Your ref:
Our ref: 23/00287/F
Please ask for: Miss Joanne Wren
Direct dial: 01553 616233
E-mail: borough.planning@west-norfolk.gov.uk

Details: **Proposed extensions and alterations to existing cottage with associated demolitions of existing side and rear extensions at Potsford Cottage Northwold Road Methwold Thetford Norfolk**

Site Address: Potsford Cottage,
Northwold Road, Methwold,
Norfolk, IP26 4PF
Client: T Betts and S Parr
Drawing Title: Existing Layout

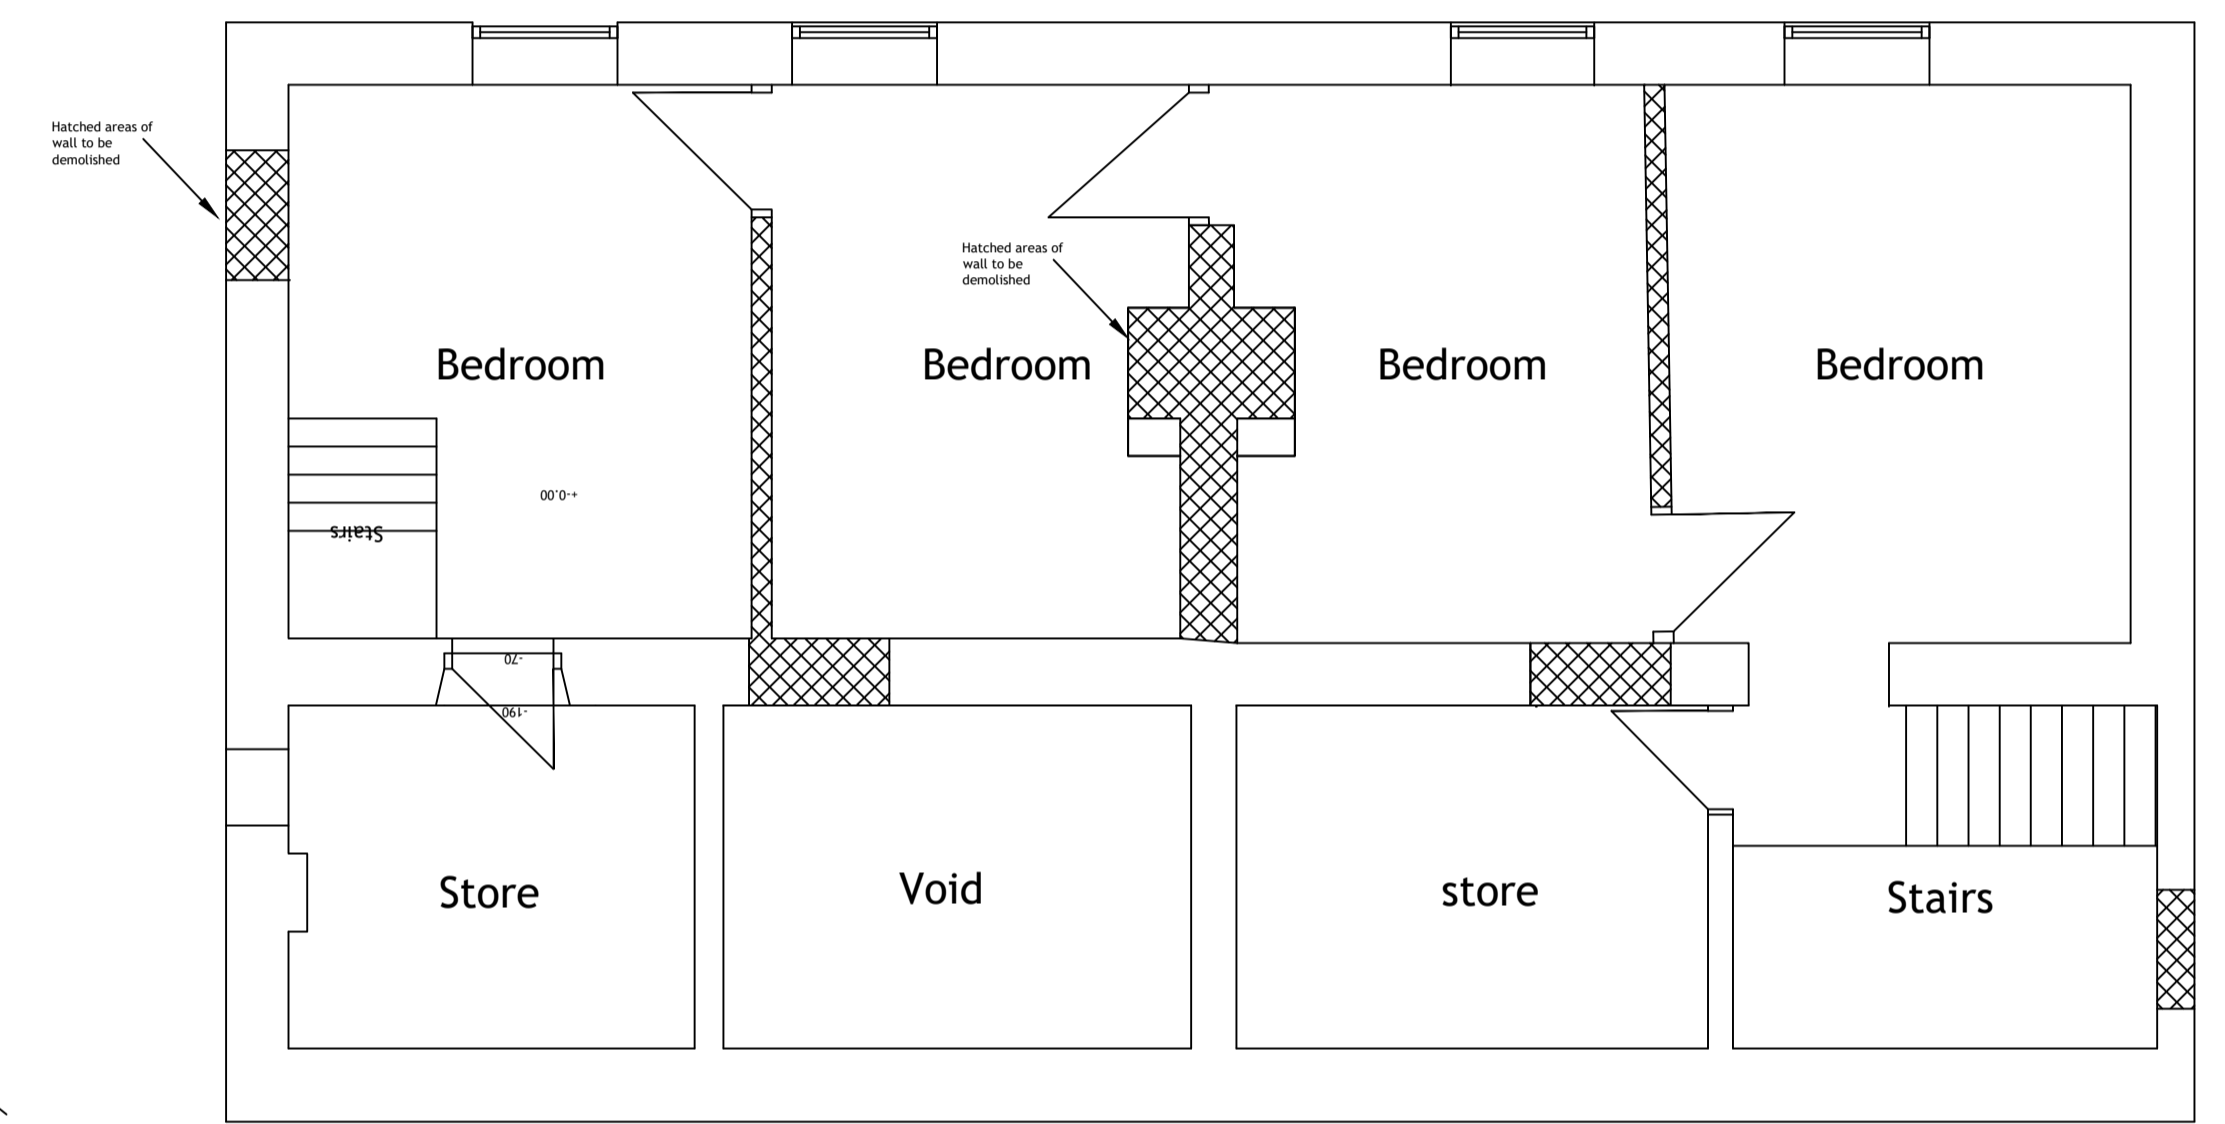
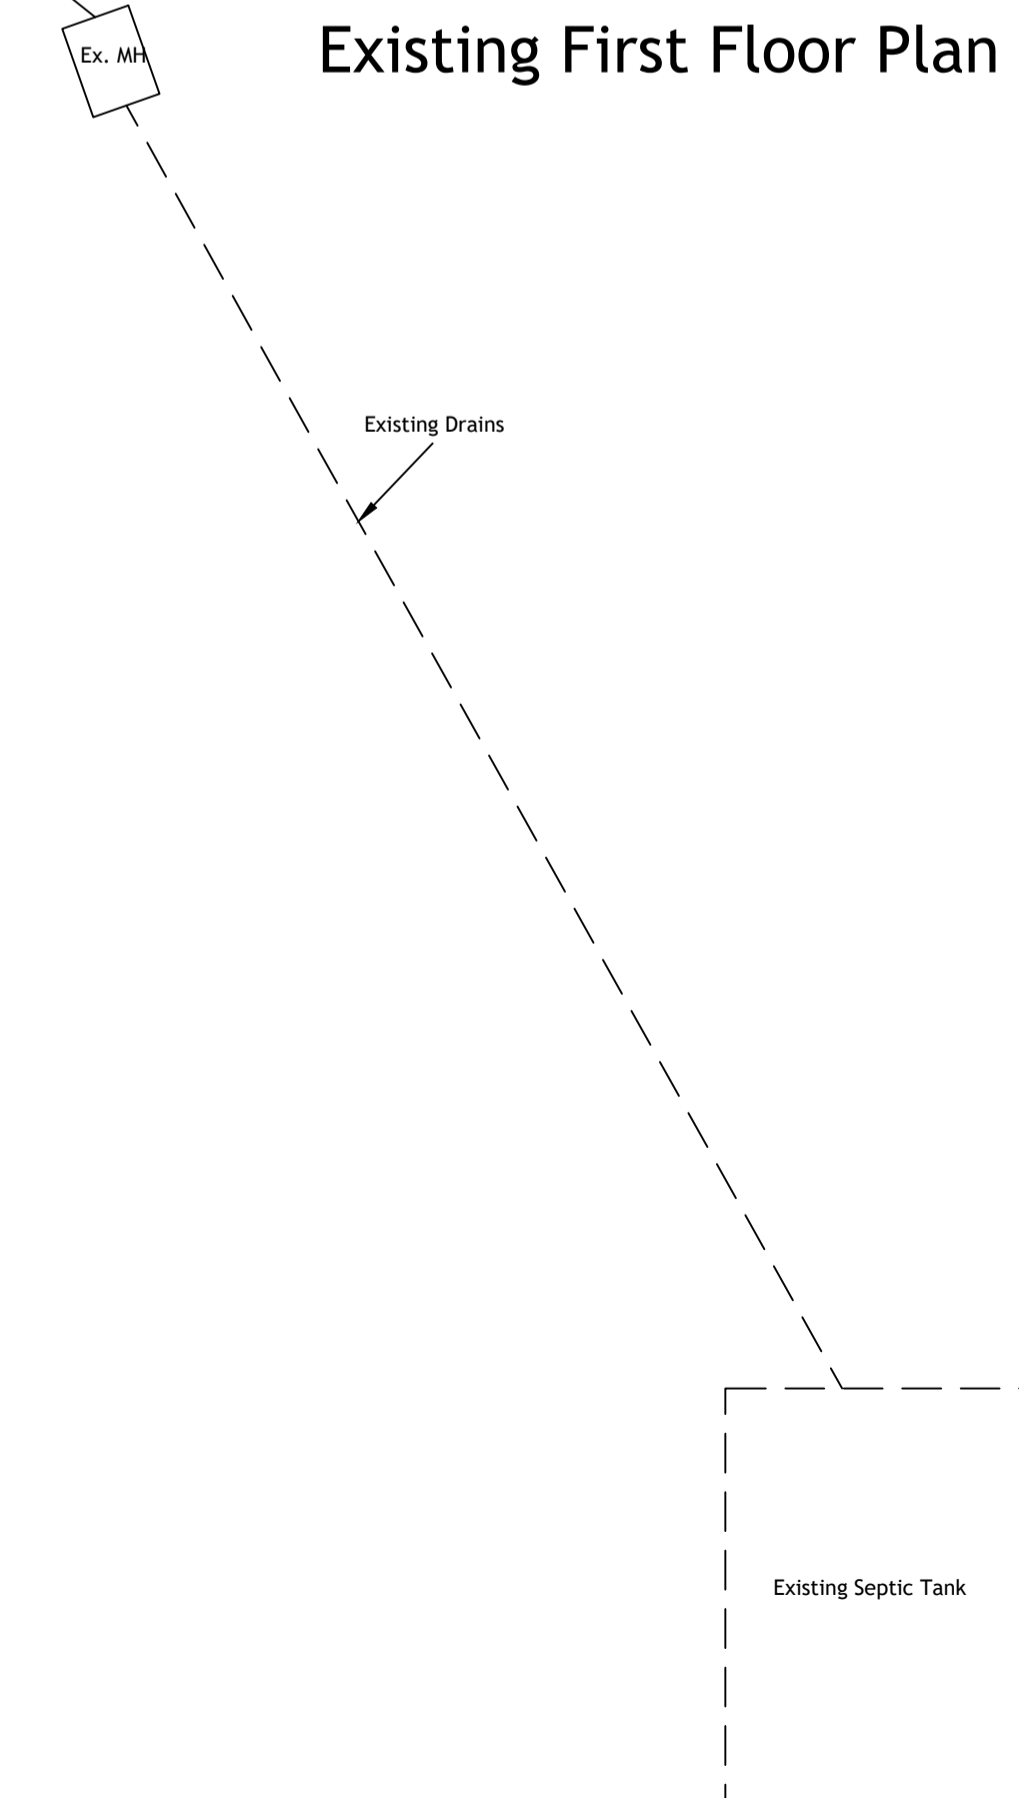
1. As the property lies within an area at risk to flooding, please complete the simplified Matrix and return it. The Matrix can be found at https://www.west-norfolk.gov.uk/info/20173/information_for_planning_agents/231/flood_risk_information
2. There is a door shown on the front elevations that is not shown on the ground floor layouts. Please amend these plans.
